27 September 2016

Our Ref: 13-0055A mrl3S96

**Re: One Carrington Street Project Section 96 Application—Heritage Impact Assessment**

1 Carrington Street (West) Elevation
 Scale: 1 : 200

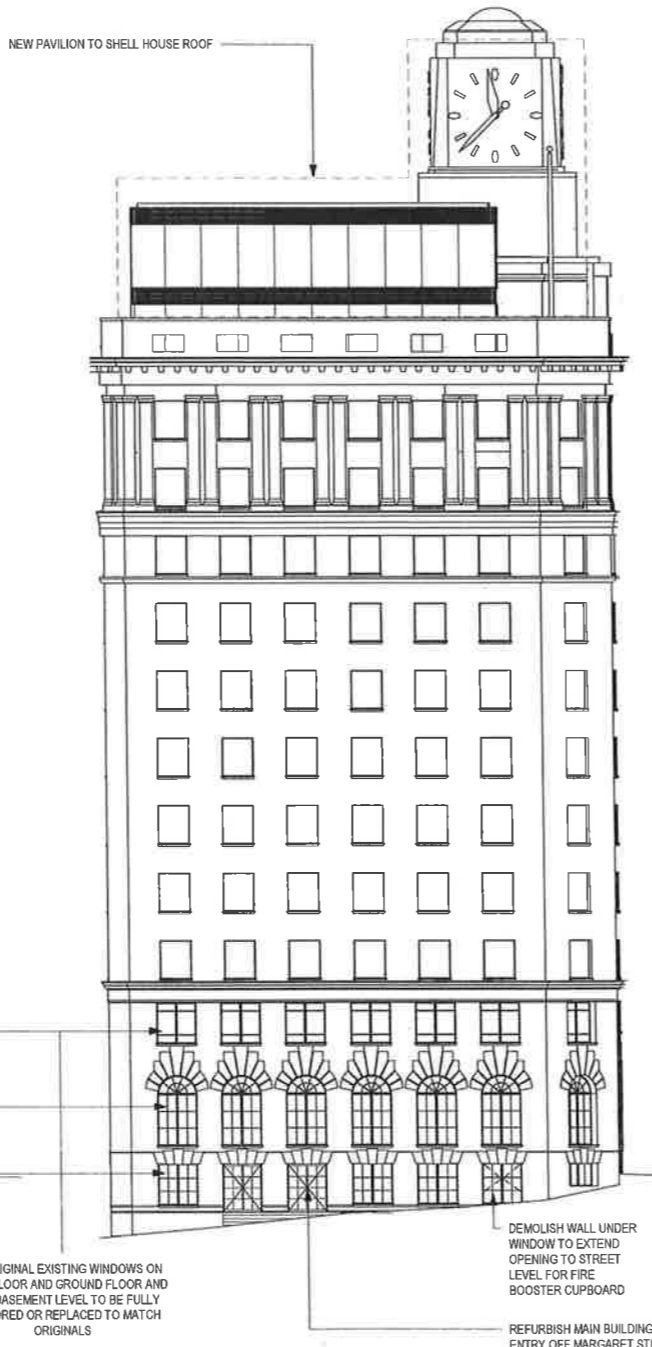
The scope of external modifications proposed for Shell House under the current S96 application is limited to alterations to the existing ground floor windows on the Carrington Street frontage.

The 3 windows proposed for removal are original steel framed elements with arched top panes, dating from 1938. The windows are separated from the original steel framed basement windows by trachyte voussoirs, which will also need to be removed to create the new door openings into the lobby. The southernmost window has previously been converted into a doorway to access a retail tenancy, but 7 out of the original 8 windows on the main Carrington Street façade are intact.

The removal of these original windows and sections of trachyte will result in some adverse impact on the heritage significance of Shell House, particularly as these elements are highly visible at street level and are key detail elements of the original Spain and Cosh design. However, the 4 original windows to the Carrington Street façade north of the original main entry will be retained and conserved, as will the 6 original windows on the Margaret Street façade. The window on the splay at the corner of Carrington Street and Margaret Street, proposed for removal and conversion as an entry doorway under the September 2016 S96 application, will also now be retained and conserved.

Overall, from a heritage perspective, retention and conservation of all of these original windows and trachyte voussoirs would be the preferred outcome. However, the fact that 11 windows in a continuous line will be retained, and the 3 windows to be removed are (along with the southernmost window already converted into a doorway) grouped to the south of the original main entry and so will appear as a conscious design statement, will mitigate the adverse heritage impact to a level that is acceptable.

- 2.9 The detail design of the new doorways proposed to replace the 3 original steel framed windows dating from 1938 on the Carrington Street frontage (and the southernmost window already converted into a door), including the removal of the original trachyte voussoirs, should consider, and be compatible with, the stylistic and material principles of the original windows.

Extract from DA2008 approved - Carrington Street Level

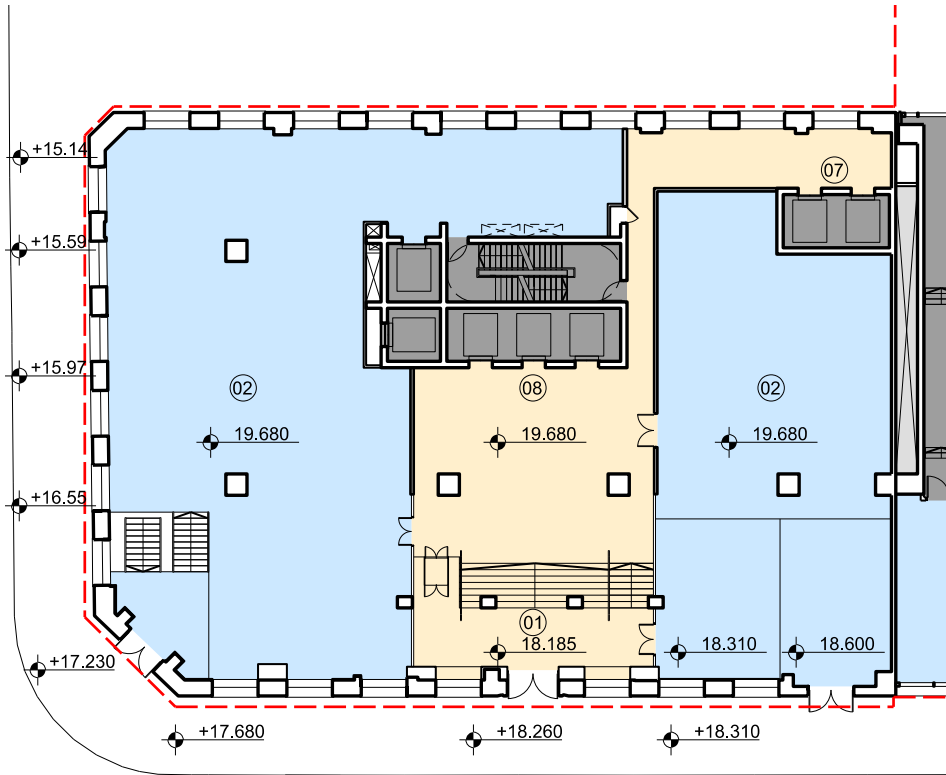
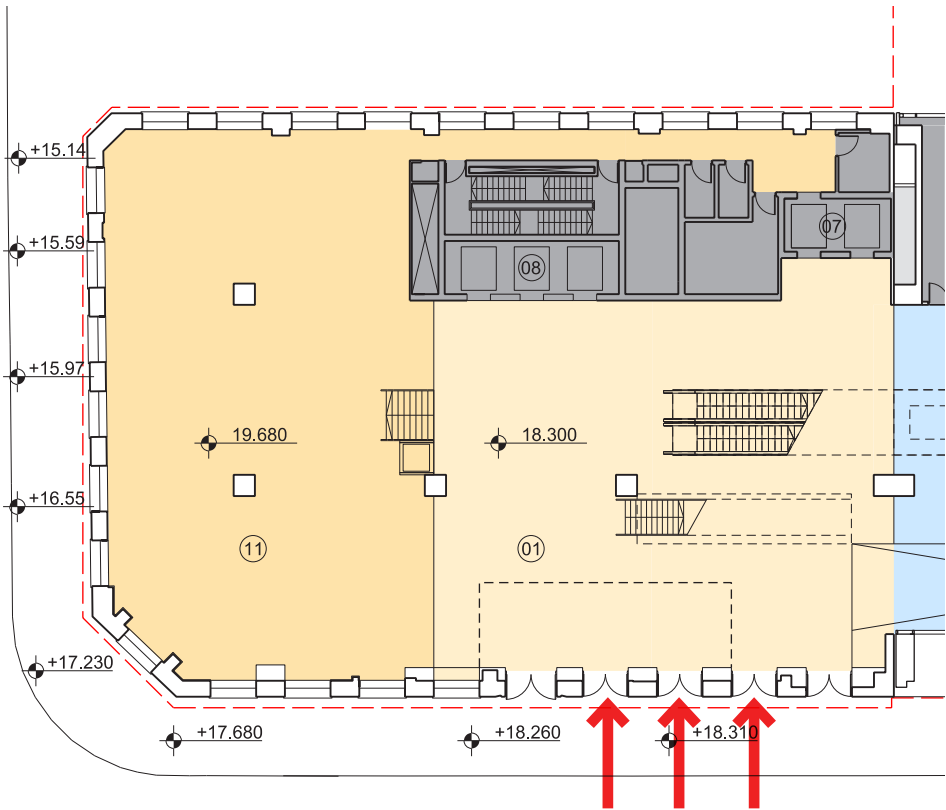
- New entrances to provide direct at grade access to the lobby space are proposed on the Carrington Street frontage, which will require the alteration of 3 existing and original windows.

It will be important however to ensure that the detail design of the new doorways, including the removal of the original trachyte voussoirs, is undertaken with due consideration of the stylistic and material principles of the original windows. Although the new doorways will inevitably be perceived as new elements, with careful attention to detail they will at least be compatible rather than intrusive in their relationship to the retained original windows.

In particular, it is essential that the detail design of the new doorways proposed to replace the 3 original steel framed windows dating from 1938 on the Carrington Street frontage (and the southernmost window already converted into a door), including the removal of the original trachyte voussoirs, is carefully undertaken with due consideration of the stylistic and material principles of the original windows. Measures to address these concerns are set out as Recommendation 2.9 in Attachment A.
